From: Anita Gardner <Anita.Gardner@arun.gov.uk>
Sent: 16 February 2021 09:46
To: Planning.Responses <Planning.Responses@arun.gov.uk>
Subject: FW: Planning Application EP/10/21/PL

From: brian akehurst [REDACTED]
Sent: 12 February 2021 16:10
To: Planning <Planning@arun.gov.uk>
Subject: Planning Application EP/10/21/PL

We have looked at the plans online, for the proposed development to our neighbouring property 4 Beechlands Close.

18 BEECHLANDS COURT, EAST PRESTON, BN16 1JZ	
Client	Description
c/o RSP ARCHITECTS LTD	PROPOSED SITE PLAN

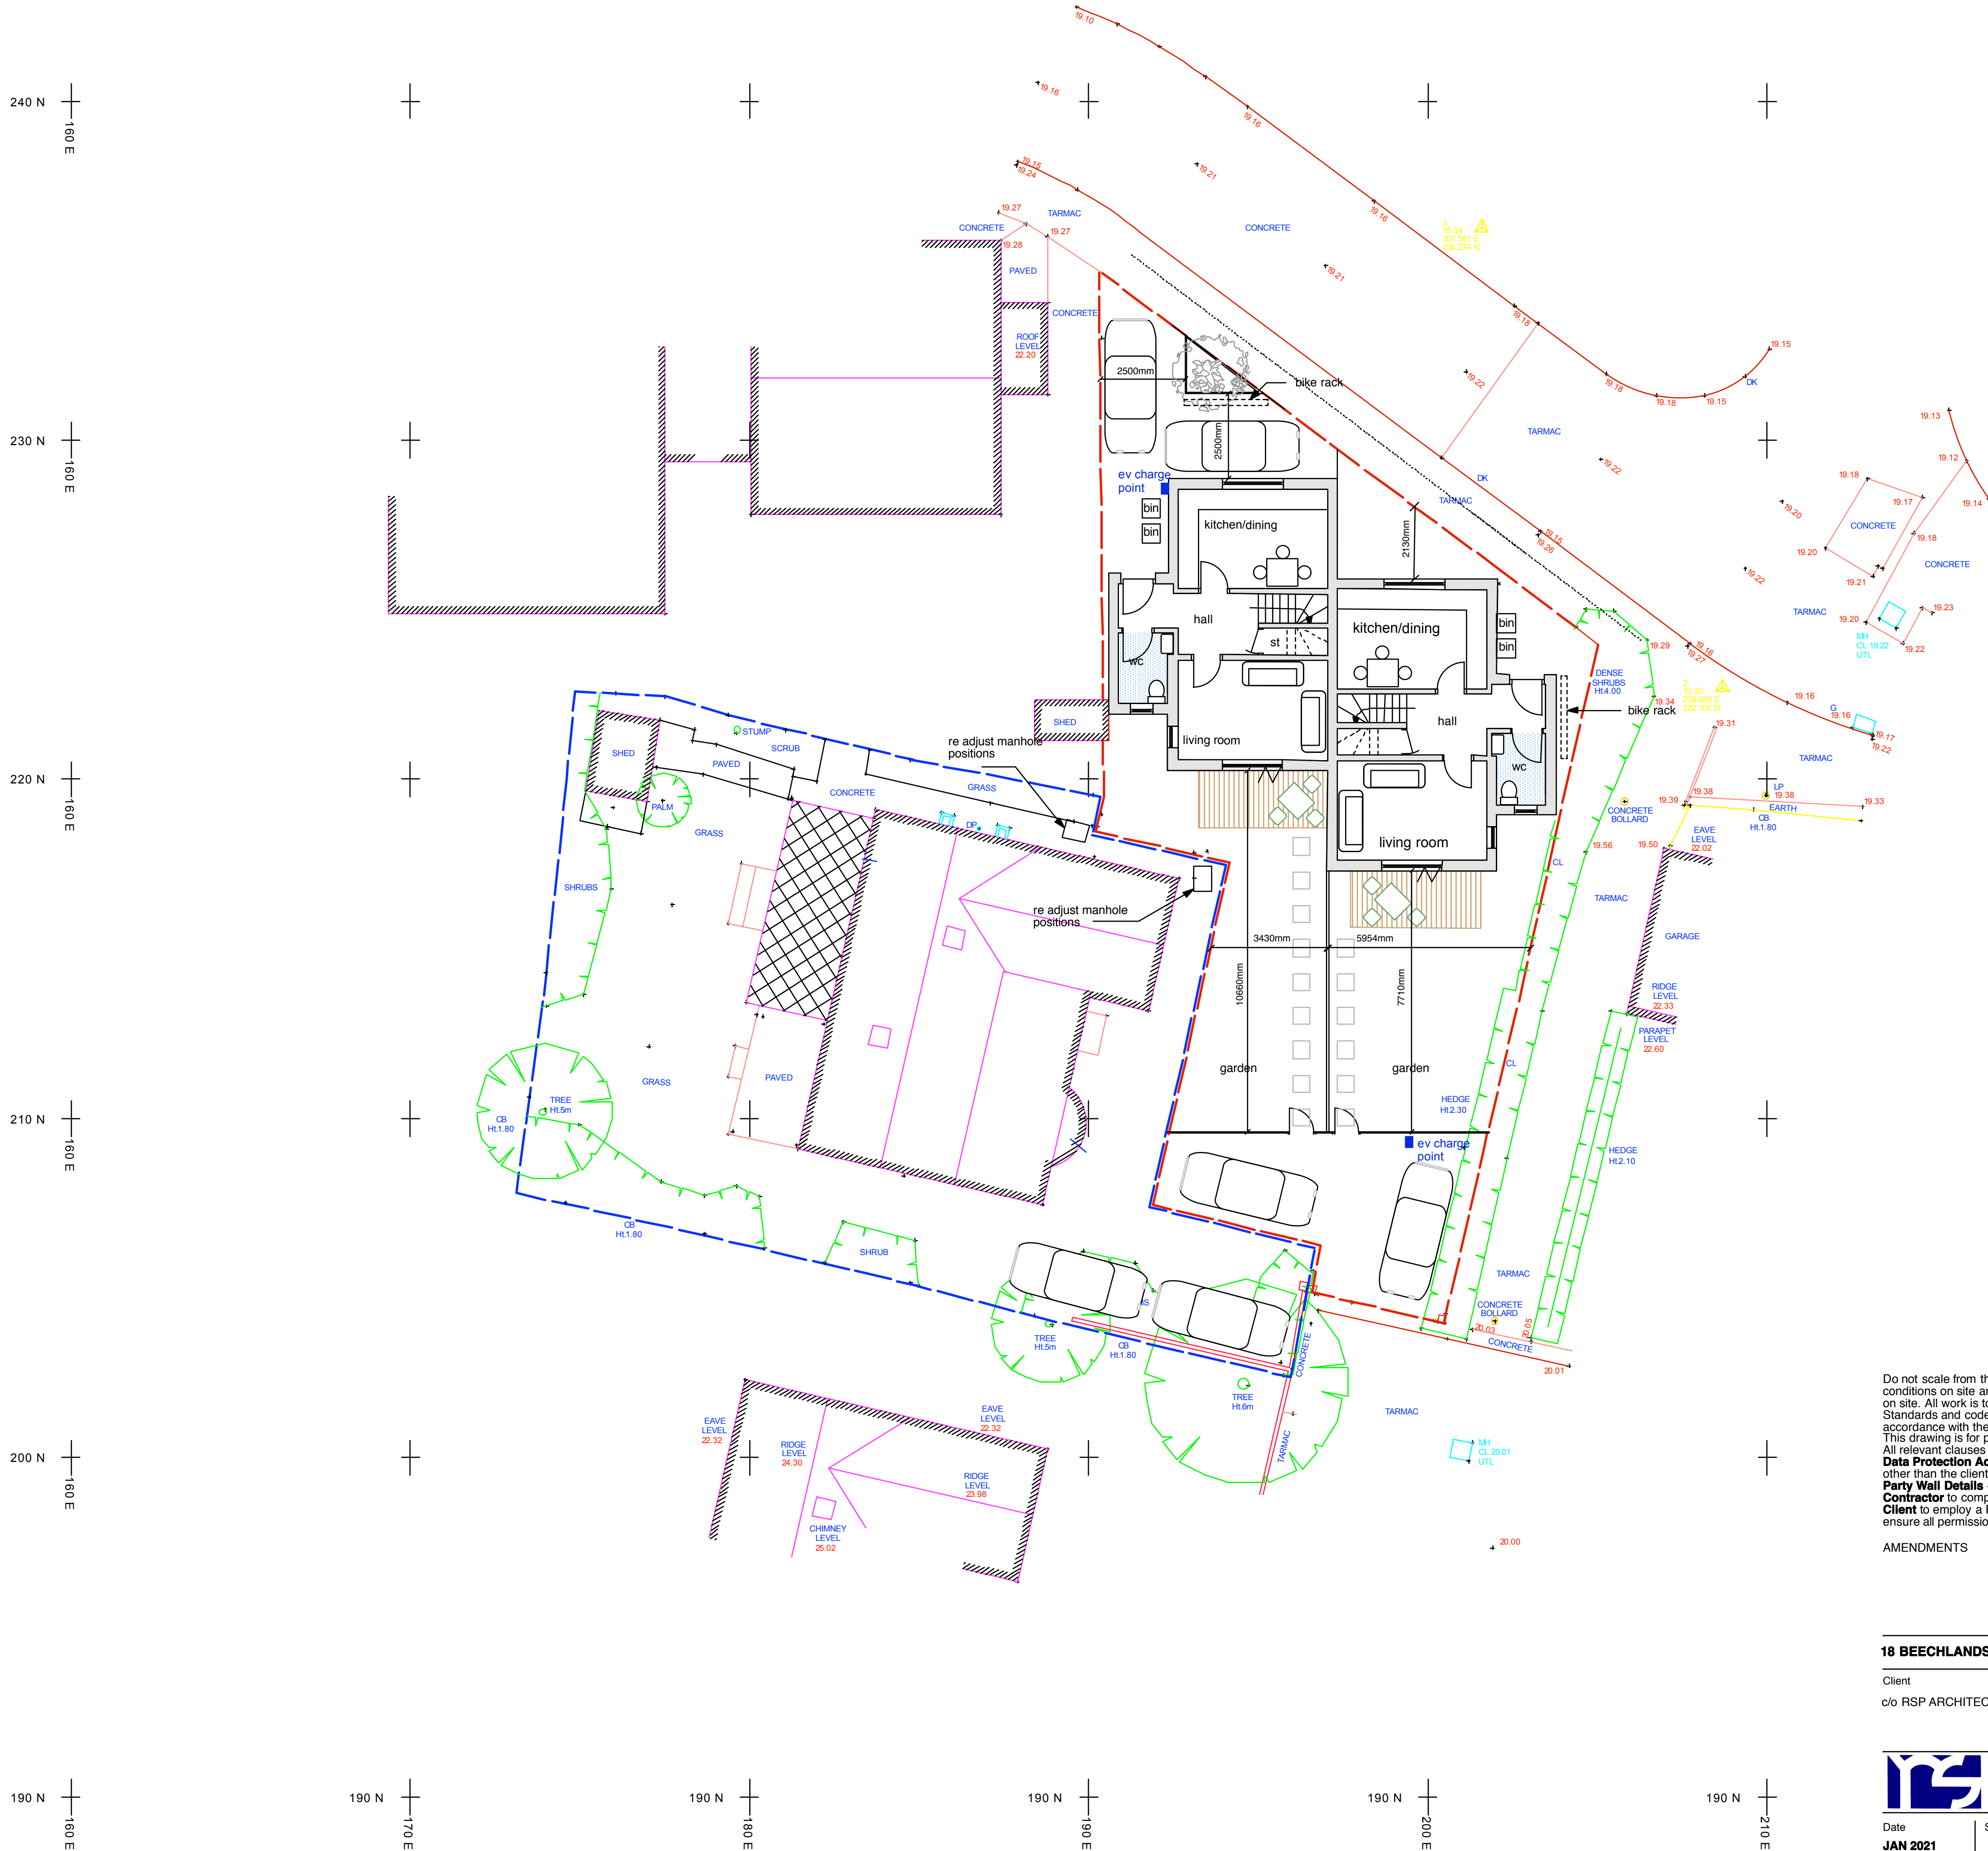
The present sewage drain is shared with us and number 4, the junction being in a manhole in our front garden. This, although, not with the present owners of number 4, has caused problems in the past with blockages. Southern Water would confirm this as they have had to clear it on a number of occasions.

As it is not clear on the plans for the proposed new dwelling houses where the sewage connection is to be, would you confirm that it will not join into the existing line in the garden of number 4 ? As that would completely overload the system. We raised this with Mr Wood when the previous application had been submitted.
